Application No: BE/59/21/PL
Site Address: 339 Chichester Road Bersted PO21 5AN
Description of works: Replacement of blockwork boundary wall with fence and new vehicular access (resubmission of BE/149/21/PL).

Thank you for your internet representation made on 7th June 2021 which has been recorded as an objection with the comments as follows:

SITE PLAN - SHOWING VISIBILITY SPLAYS
1:500 SCALE (at A3)

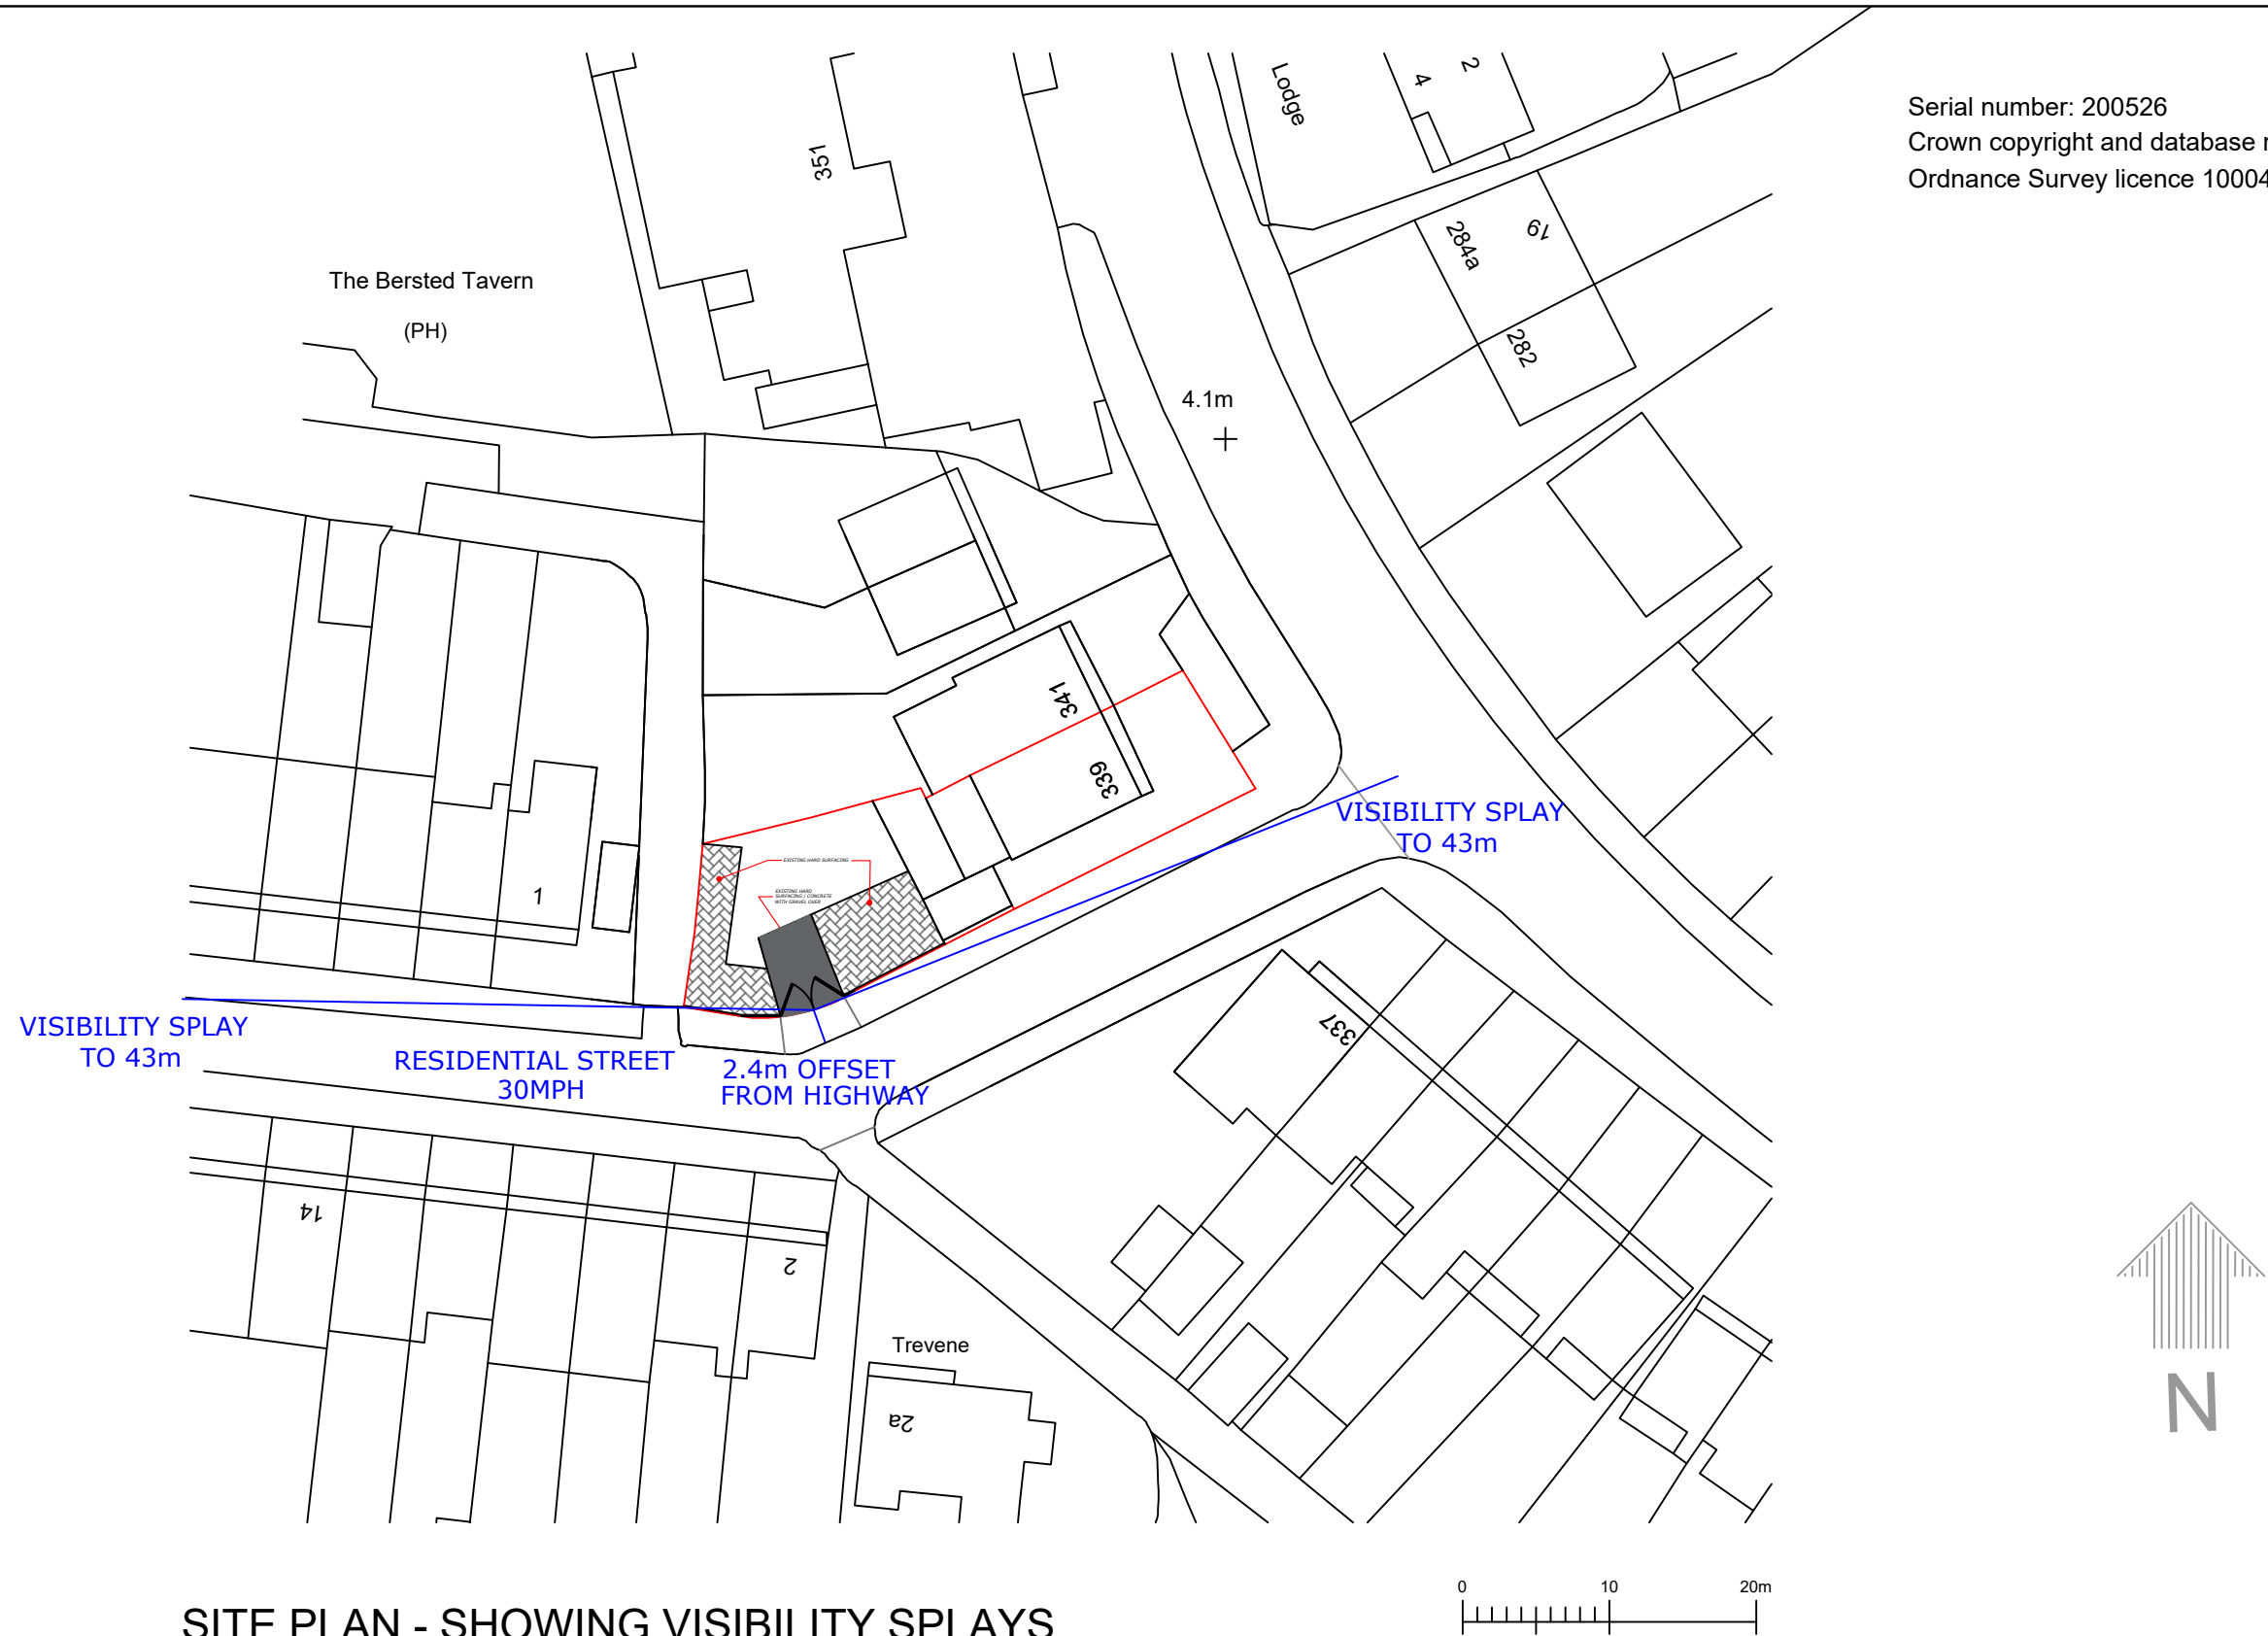
This application is making a very busy end of the road even more congested. There are cars parked both sides of the road which can almost cause accidents when coming round the corner. Then the potential of trucks and vans parking and turning in the road and into the back entrance of a house is totally dangerous. Businesses like this should be on business parks not residential roads. Children coming and going to school use the road and this could be putting the safety of the children at risk.
